WILLOWTREE PLANNING

REF: WTJ21 –151

**PROPERTY AT 48 VICTORIA ROAD AND 2A-2B GORDAN ROAD, ROZELLE
SSD-27208140**

We write in response to the **SSD-27208140**, for the St Aloysius College (SAC), Rozelle Campus. Specifically, this letter and attachments provides a response to the additional Request for Information (RFI) dated 27 May 2022. This RFI responds to the meeting held with Inner West Council and the Department of Planning and Environment (DPE) on the 23 May 2022. The applicant, St Aloysius College, and its specialist consultant team have reviewed and considered all matters raised in this RFI, which relate to traffic and heritage. **Table 1** below provides a detailed response to the key matters raised and outlines the proposed amendments to comply with these matters.

Car Park Mark Up p

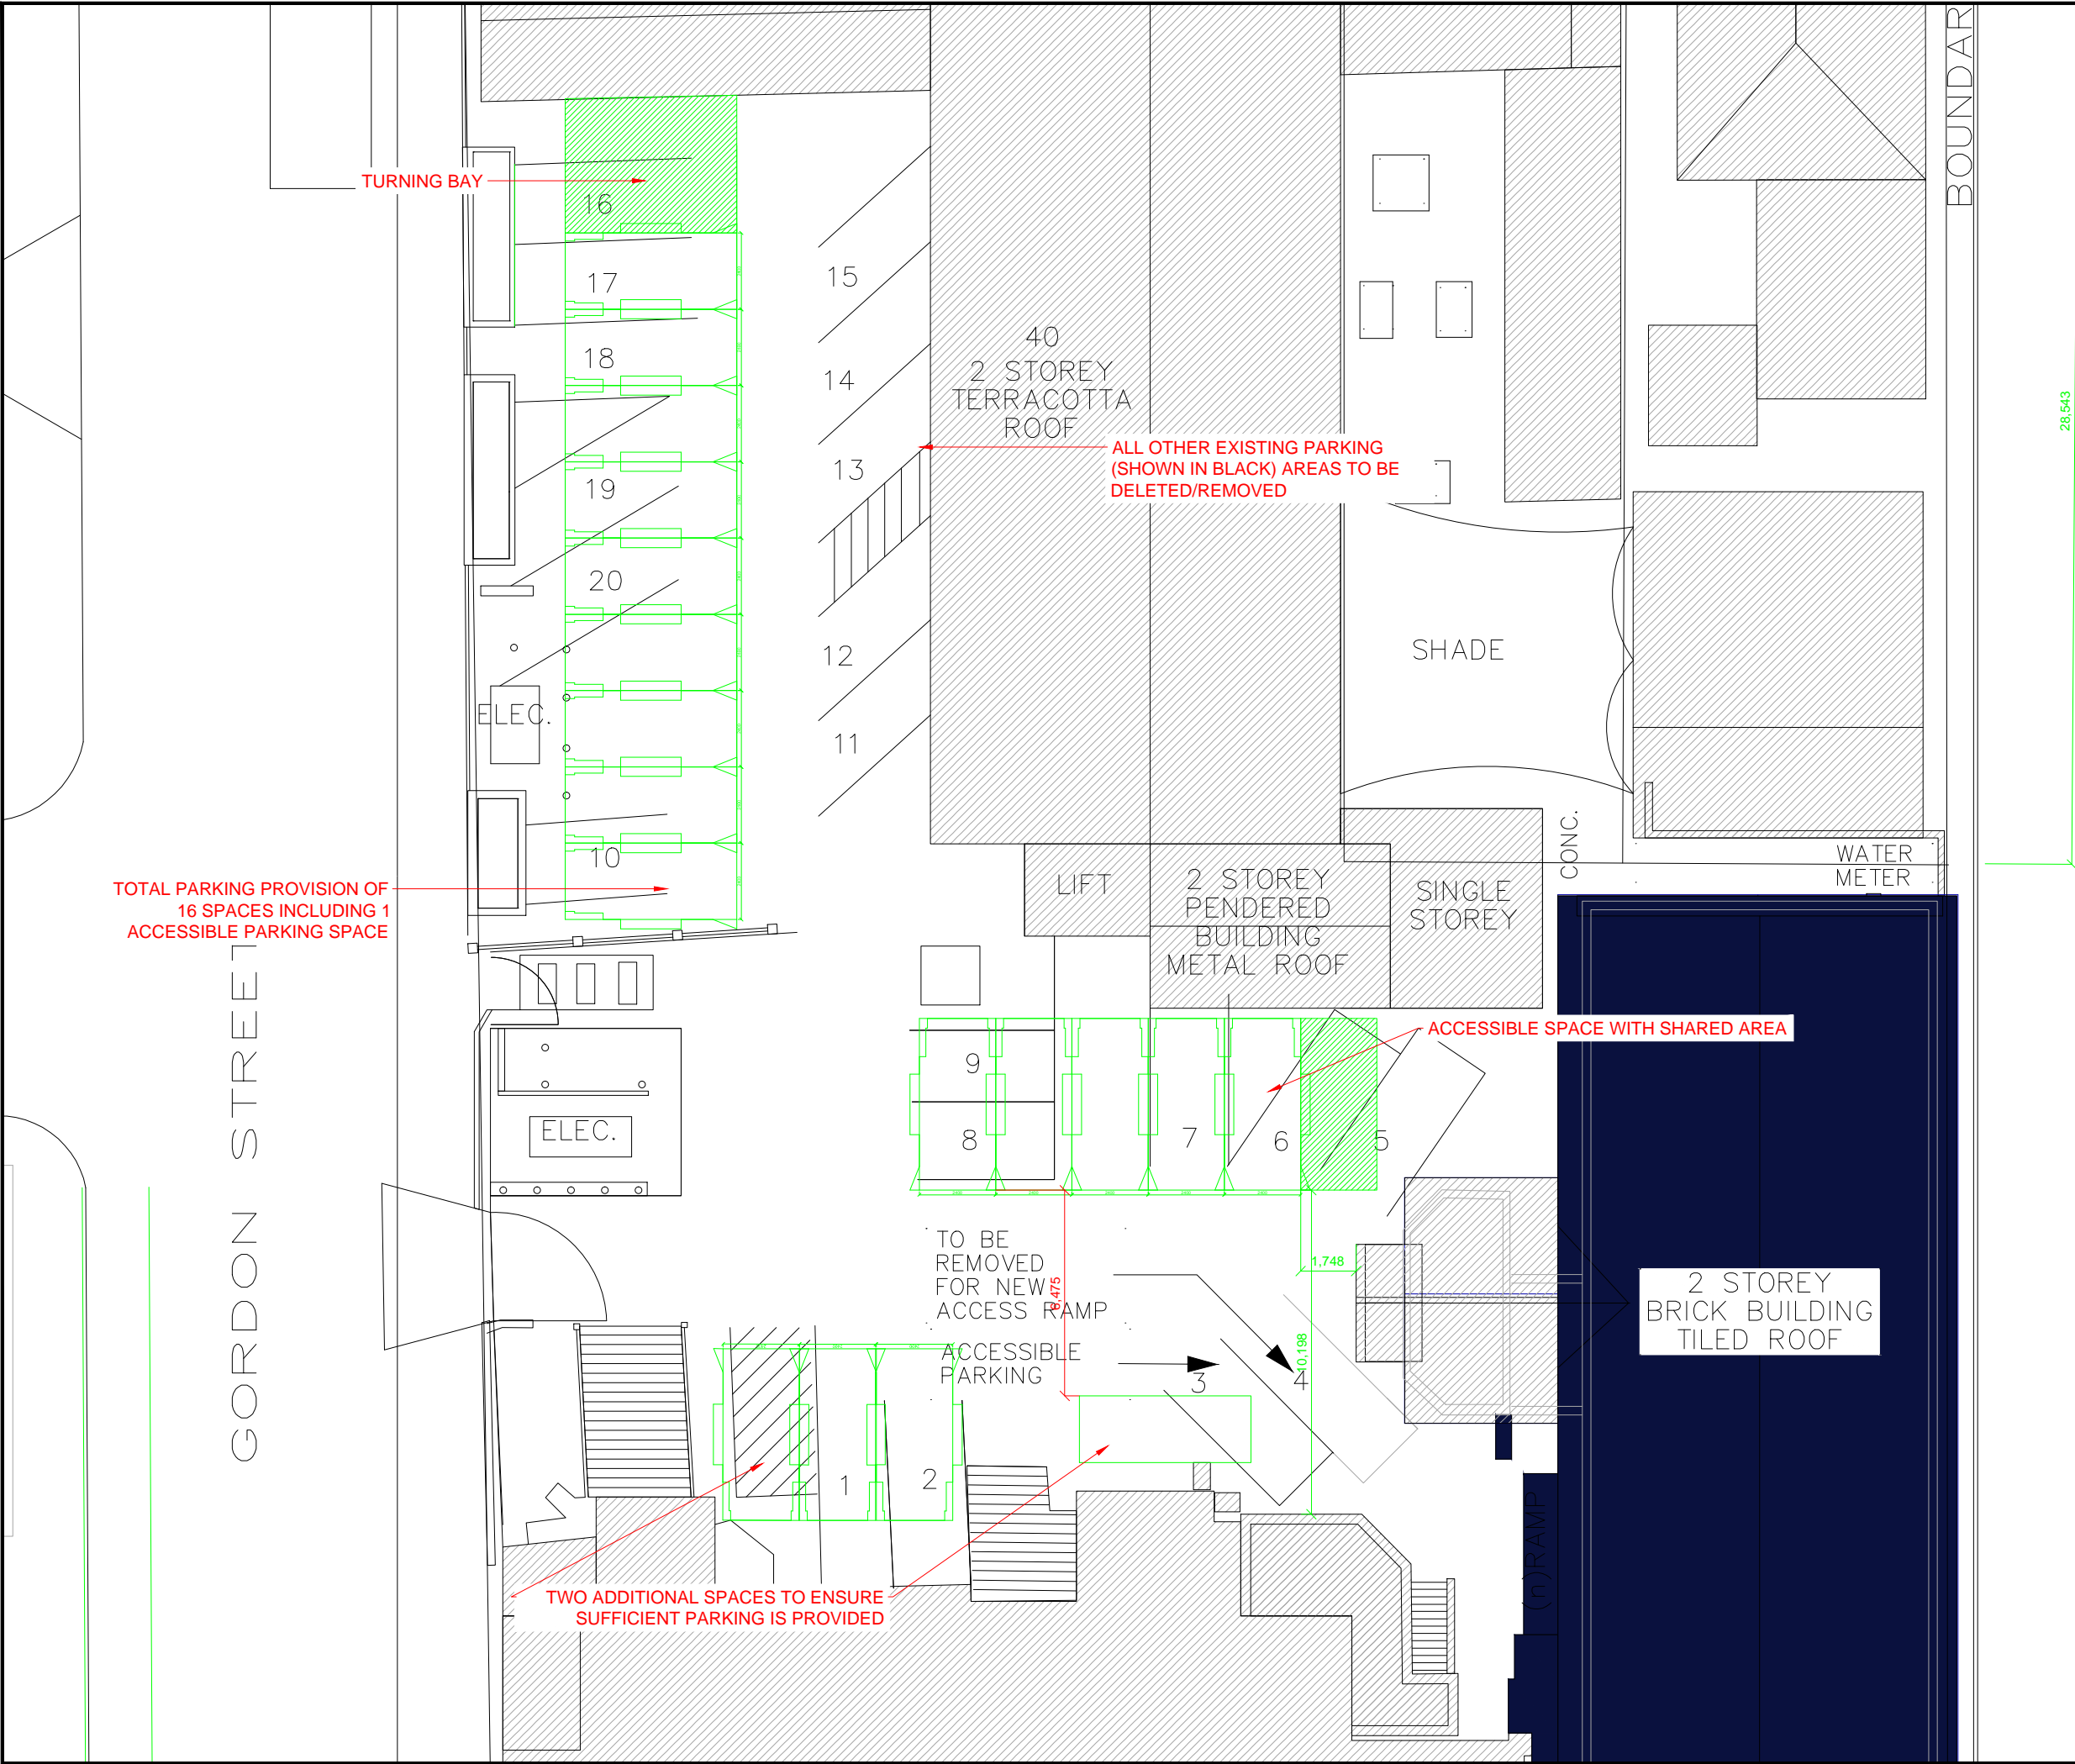
<p>The previous consent on the site required the carpark to be upgraded to comply with AS2890.1:2004. Appendix C of the TAIA details the new compliant layout, which reduces the on-site parking availability from 20 spaces to 16 spaces. However, the TAIA does not acknowledge the reduction in on-site parking and the impact this will have on the off-street parking demand.</p>	<p>In addition to the 16 spaces available on site, there is the ability to provide an additional two (2) spaces to be line marked within the carpark. This will provide a total of 18 spaces for all uses on site. Therefore, up to three (3) spaces will need to be accommodated on-street during the rare occasion when all three (3) land uses will be operating on-site. The parking surveys demonstrate sufficient capacity for on-street parking for this to be accommodated.</p> <p>This is addressed in further within the TAIA (Appendix 2) and traffic response (Appendix 3).</p>
